Five Estuaries - Deadline 6 Submission

On behalf of my clients, T. Fairley & Sons ltd, I am writing to provide an update on work undertaken by my client and the Applicant in relation to screening proposals. This has partly been recorded within the technical note: 10.20.8 Technical Note - SCREENING PLANTING OPTIONS FOR LAND PLOT 17-024. Document Number: 10.20.8 REP4-038.

The alternative potential option for landscape screening of Normans Farm within plot 17-024, titled "Normans Farm Layout 3", which was discussed at a meeting on the 22nd November 2024, is the preferred Layout of the three proposals, however, subject to the following outstanding amendments/concerns:-

DRAWING NUMBER: 05356.00010.0451.0

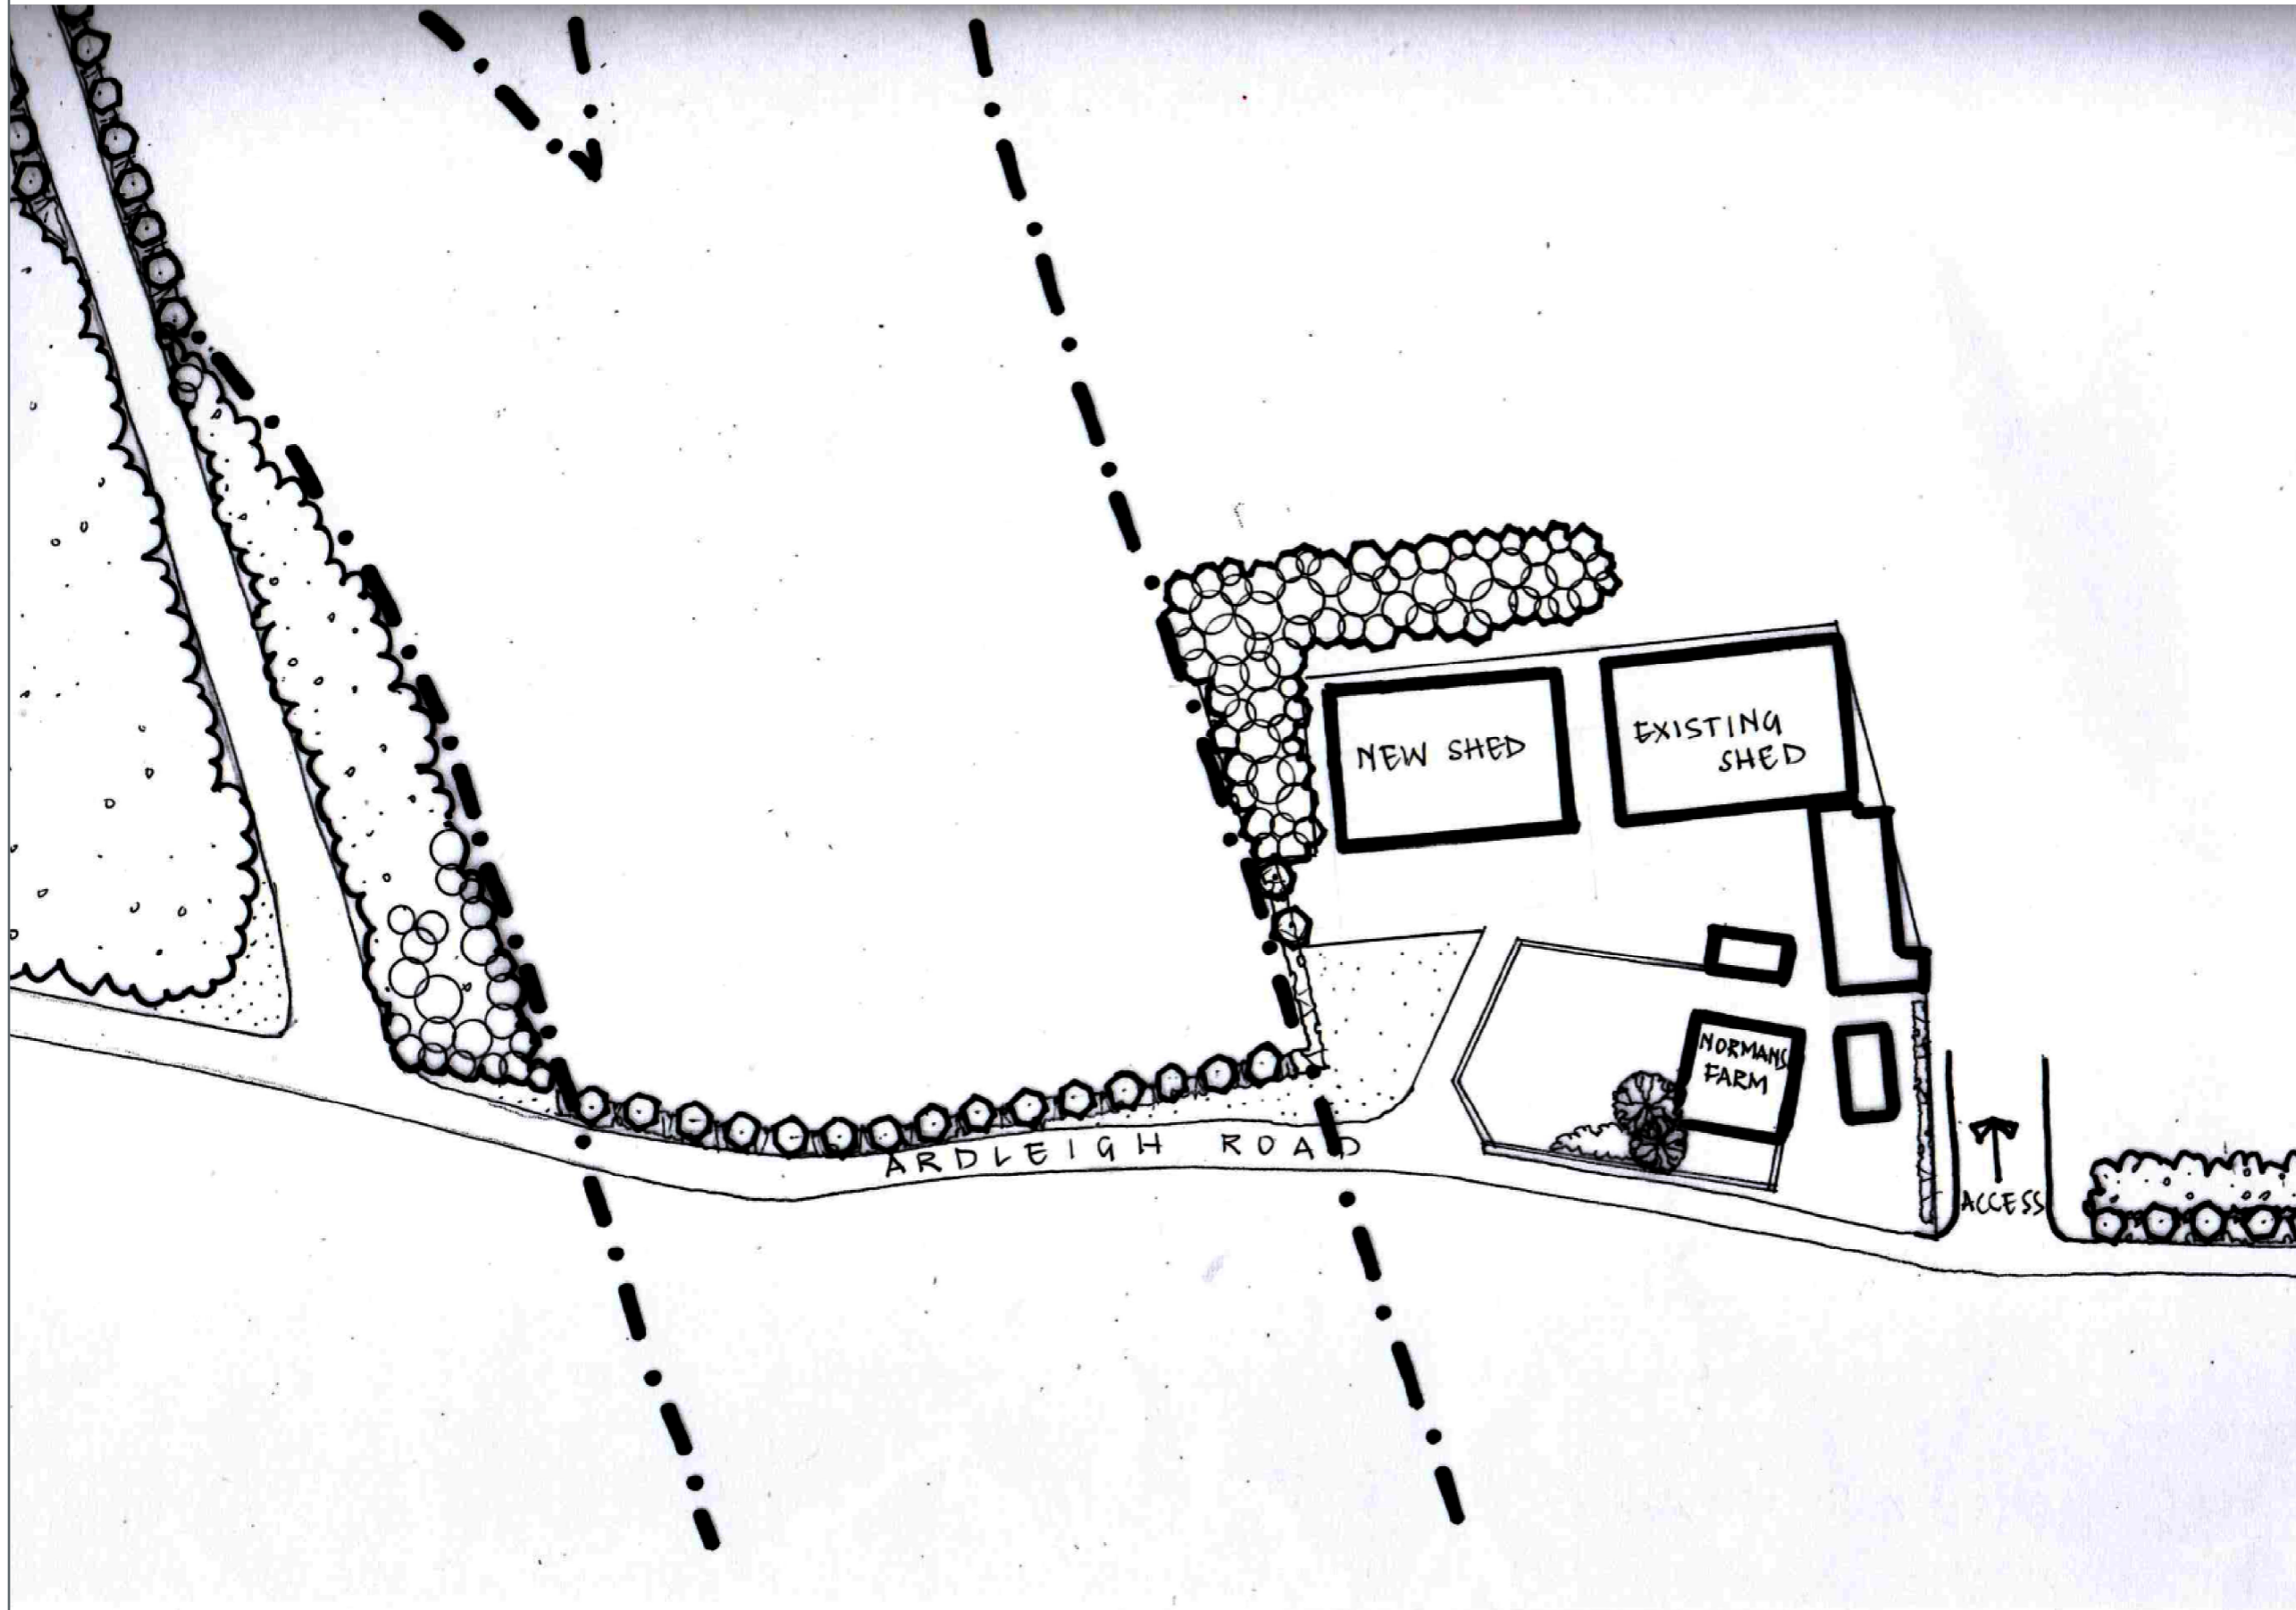
- b. The screening proposal to the north and west of the New Shed only allows for a circa 5,000 sq. Ft building, which is insufficient for the demands and requirements of my clients farming business.

- c. The screening proposal does not allow for access into the western gable end of the 'New Shed,' and with the proximity of the of the New Shed to the Existing Shed, access would not be available into the eastern gable end either, rendering the New Shed useless/land locked. This emphasises how Layout 3, despite having moved the screening belt away from the yard, still prohibits all future yard extension and construction of new buildings. We cannot stress this enough, that my client cannot be in a position where they are unable to extend their yard or construct new farm buildings. This will totally restrict future business growth, which is not a position the Applicant should be putting my client in.

- d. It was understood that the New Shed would remove the need of a screening belt around the yard, thus preventing any future sterilisation. It was also discussed during the meeting on 22nd November 2024, that by Five Estuaries (and North Falls), constructing a new building on our clients behalf, it would remove the need for both projects to acquire the land at the proposed rate, removing the costs in establishing the screening belt and removing an element of management liability for the screening belt, thus being a possible cost equal exercise. This proposal would clearly benefit all parties, and especially my client as no screening belt would prevent any restrictions on future expansion of the yard and buildings. To reemphasise our concerns, our client cannot and must not be in a position where the future growth of their business is prevented due to the presence of the screening belt.

- e. My client, being the only party who stands to benefit from the screening proposals north and west of the yard, is content with having a new farm building to screen the substation, as opposed to a screening belt, in order to protect the future of the farming business.

- f. As to the proposals of Establishing a screening belt along the northern edge of Ardleigh Road, this will have a detrimental impact to the arable land immediately to the north as during the winter months, the soil will not dry out as it will always be in this shadow of the screening belt. We appreciate and understand the need for a screening belt along this stretch of road, protecting the vista from users of Ardleigh Road, however, we request with the screening belt could be kept as sporadic and low as possible, to protect the productivity of the soil immediately to the north.

- g. As to the access to the east of Normans Farm and as shown in Normas Farm Layout 3, we had agreed with the Applicant agreed sufficient width would be removed from the screening belt to allow future access for large agricultural machinery and which my client would retain ownership of. The Normans Farm Layout 3 proposals show such access. We support such access to the land to the east of Normans Farm, and the proposals as per the Applicants drawing suggests the access is circa 27 meters wide. This allows for future agricultural uses and provides a 'corridor' for future services being laid (for uses such as irrigations mains, electricity supplies, etc). In any case, we cannot have an access any narrower than 20 metres. We also agree with the positioning of the access, as the existing buildings will provide a natural visual screen from the substation site for Ardleigh Road users, thus providing the opportunity to not establish a screening belt for the last circa 27 metres, as drawn.

- h. As to the position of the cable corridor, and whilst we appreciate the corridor delineates a 'worst case scenario', perhaps it would be best for Five Estuaries (and North Falls) to use all best endeavours to microsite the cables to the western side of the proposed corridor, thus providing the opportunity to further extend the yard to the west in due course.
